**A122 LOWER THAMES CROSSING (REF: TR010032)
DEADLINE 6 WRITTEN REPRESENTATIONS**

MELVILLE HAMILTON LOWE MOTT – AFFECTED PARTY REFERENCE: AP1308

C H L MOTT & M MOTT – AFFECTED PARTY REFERENCE: AP1369

On behalf of our above clients, the Mott family, we write further to Compulsory Acquisition Hearing 3 ('CAH3') held on 17 October 2023 with our written submissions in support of the oral representations made at that hearing.

**SPECIAL CATEGORY LAND PLANS**  
REGULATION 5(2)(3)(4)  
SHEET 20

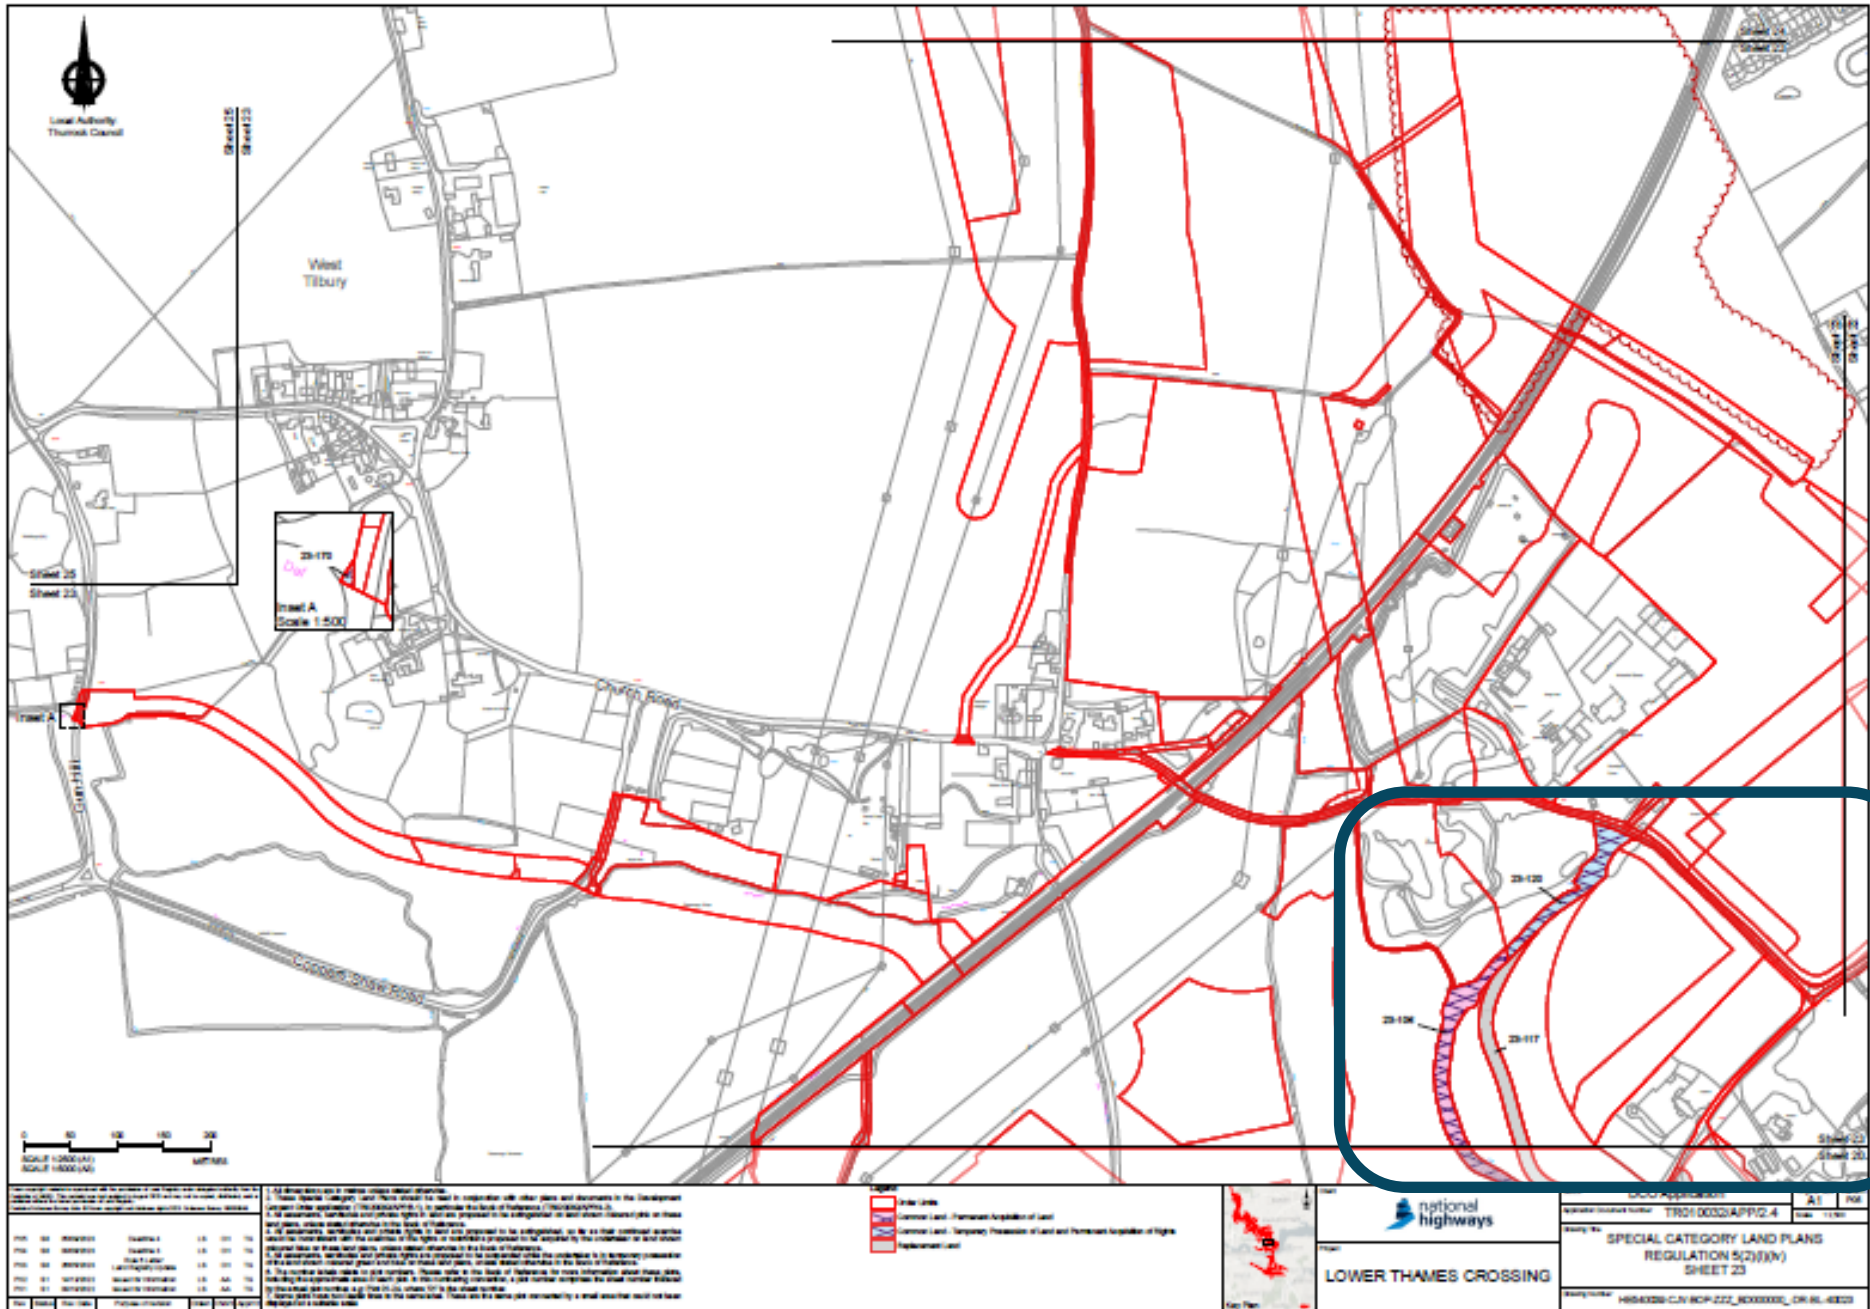
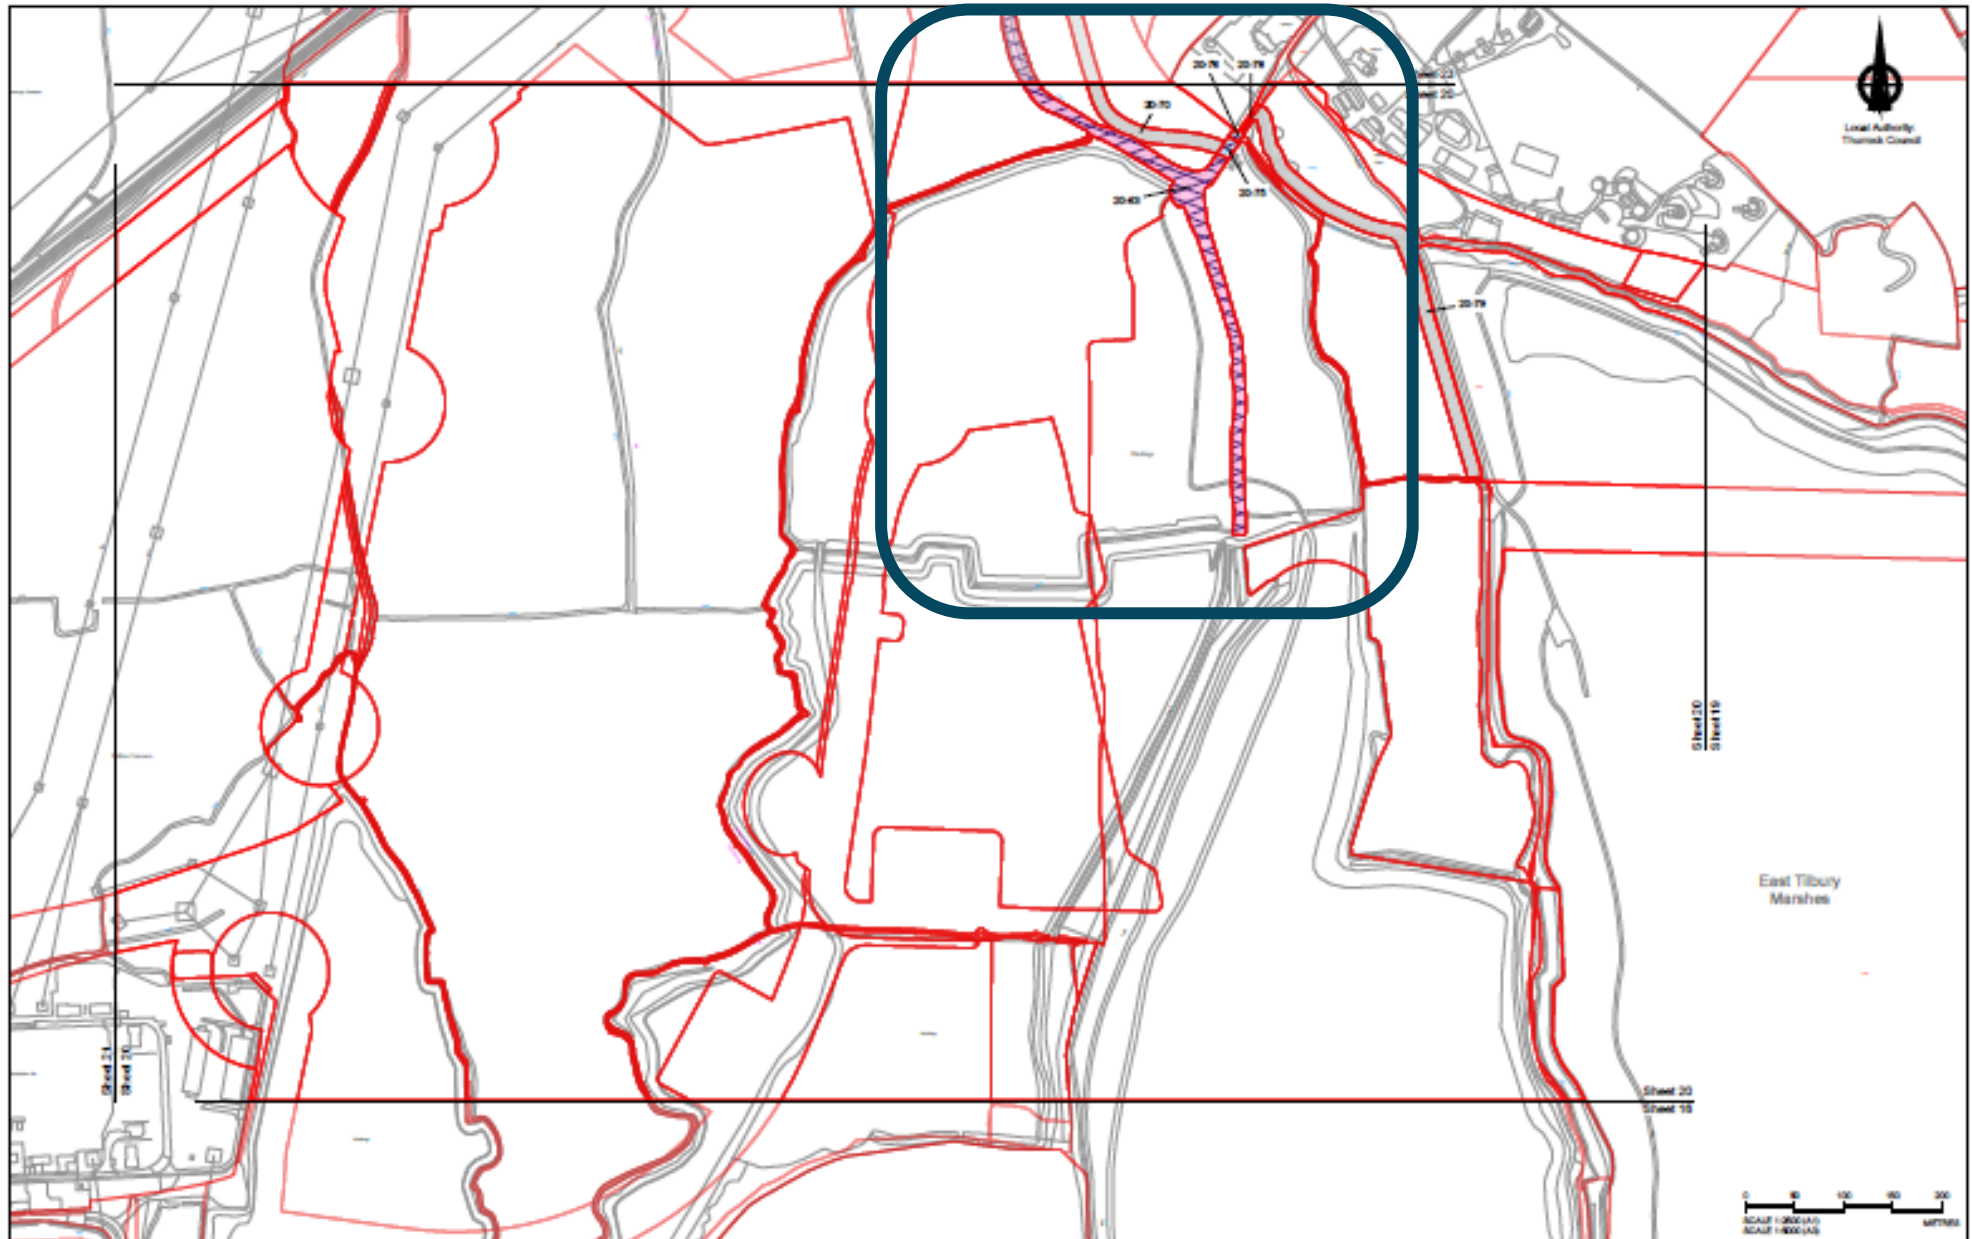
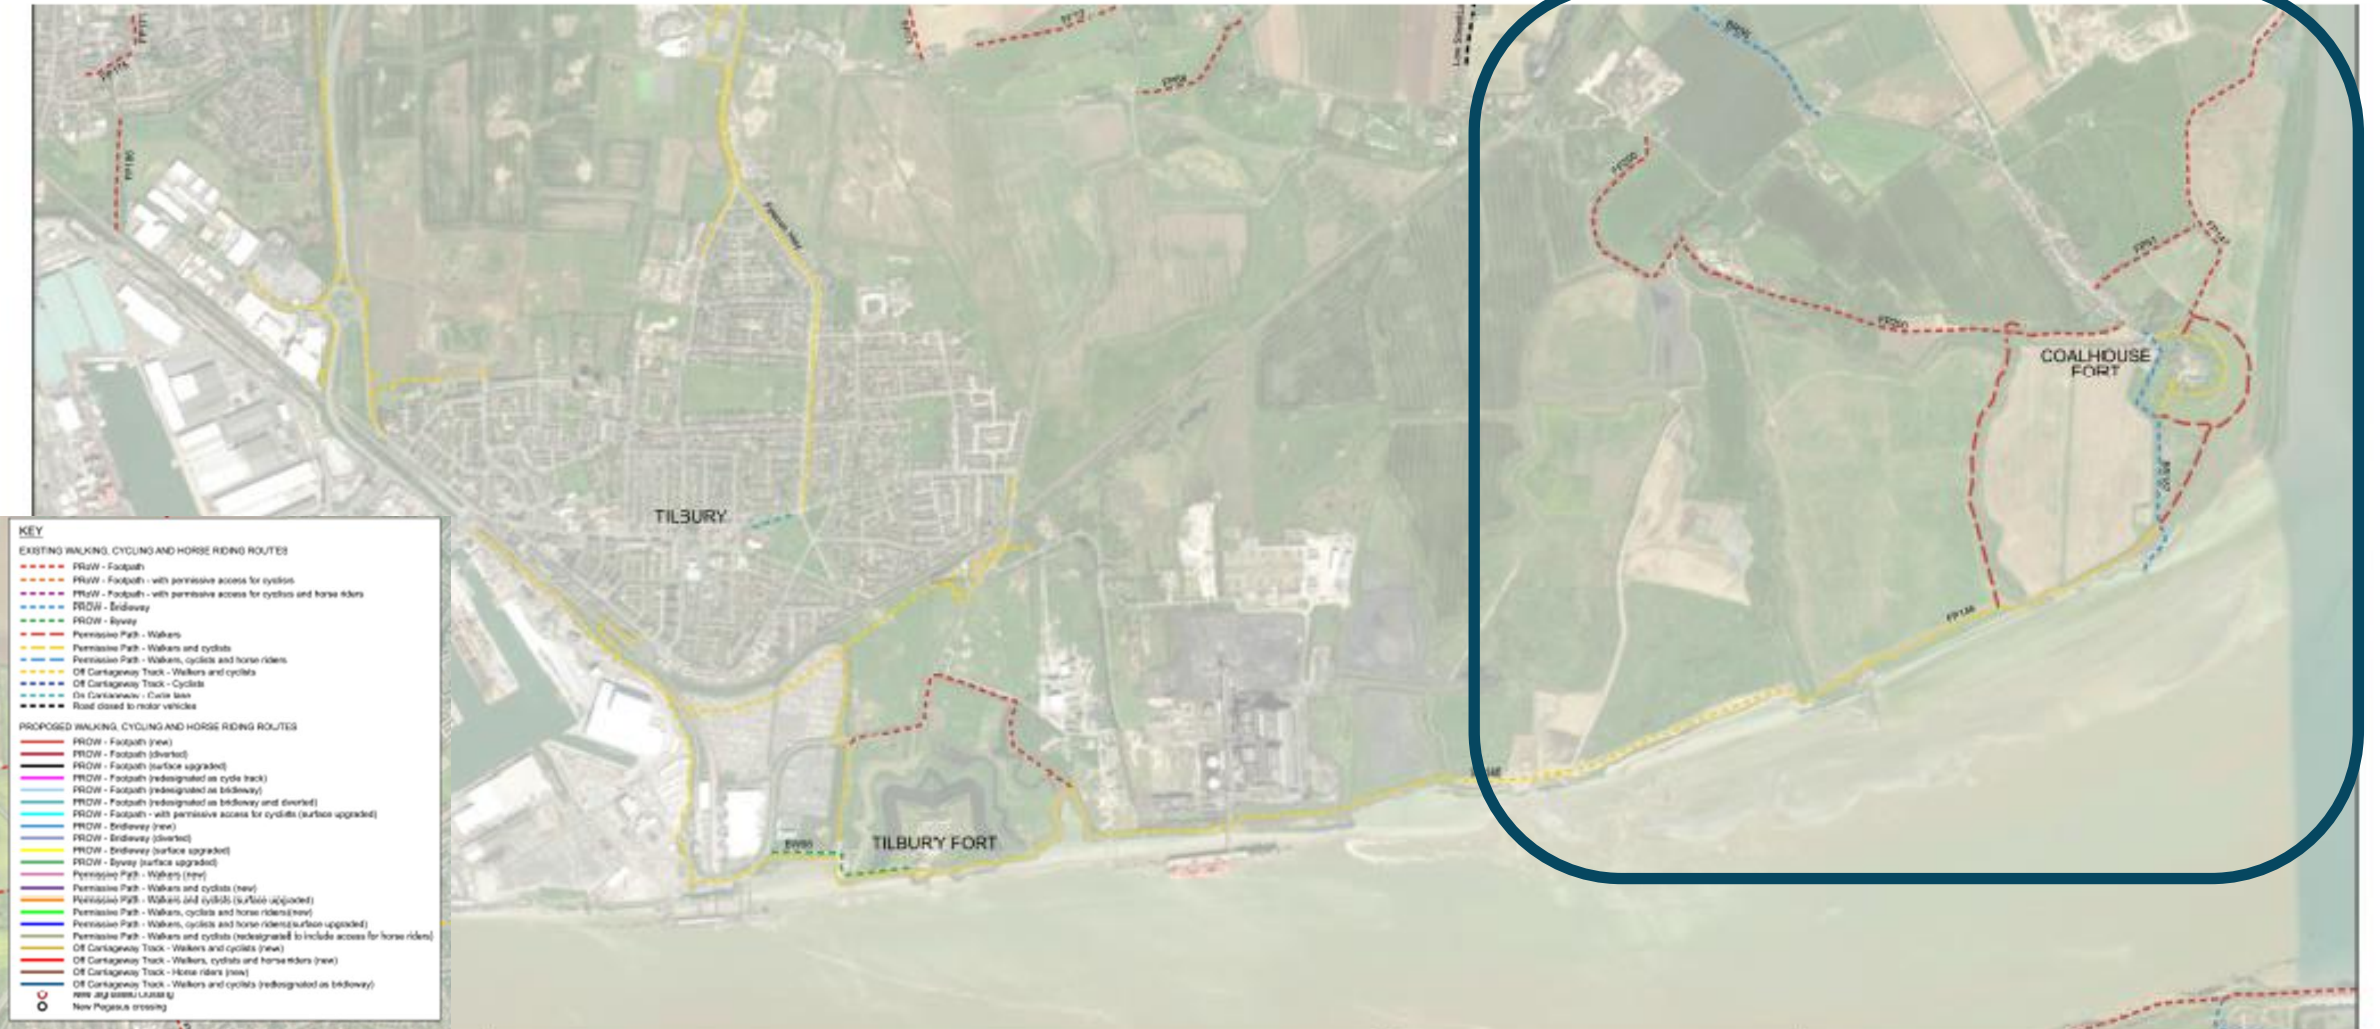
Special Category Land	<p>Plates 34 & 35 - show the existing route of the old Drove shaded blue - and the proposed replacement land shaded grey.</p> <p>Our client objects to the permanent acquisition of land for this purpose and the replacement of the Drove on their freehold land.</p>
WCH Routes	<p>Plate 36 - is an extract of the Applicant's WCH route plans from REP2-073 and show the existing rights of way</p> <p>Plate 37 – is an extract of the Applicant's WCH route plans from REP2-073 and show the existing and proposed rights of way</p> <p>Plate 38 - shows the relationship of the proposed rights of way on Tilbury Fields to our client's retained land and jetty/wharf and the required access as set out above.</p> <p>Plate 39 - shows the severance issues of permanent acquisition for proposed WCH routes on land that is both outside the Order Limits and where a ransom strip would in effect be created with such permanent acquisition on our client's land north of Station Road and which is subject to temporary possession by the Applicant and therefore is relevant in the context of our clients ownership and occupation post construction.</p> <p>Plate 40 - shows the location of our client's residential property at Goshems Farmhouse adjacent to the new proposed WCH route</p> <p>Plate 41 - shows the location of the proposed routes bisecting/severing Mulberry Strategic Land development parcels 1A, 1B, 3A-3D</p> <p>ISSUES:</p> <p>Referring to 7.4 Project Design Report Part E: Design for Walkers, Cyclists and Horse Riders APP-512:</p> <p>2.1.4 – '<i>A latent demand to walk and cycle in the Tilbury area was theorised</i>' – we are unclear as to how such a significant additional burden as created by the proposed rights of way can be based on a theorised baseline.</p> <p>The Project Design documents refer to design anticipating future development but there has been no regular stakeholder engagement as far as we are aware with landowners or their development partners as to in the development of the Applicant's WCH routes and how those would fit with retained land use, wider issues associated with management and</p>
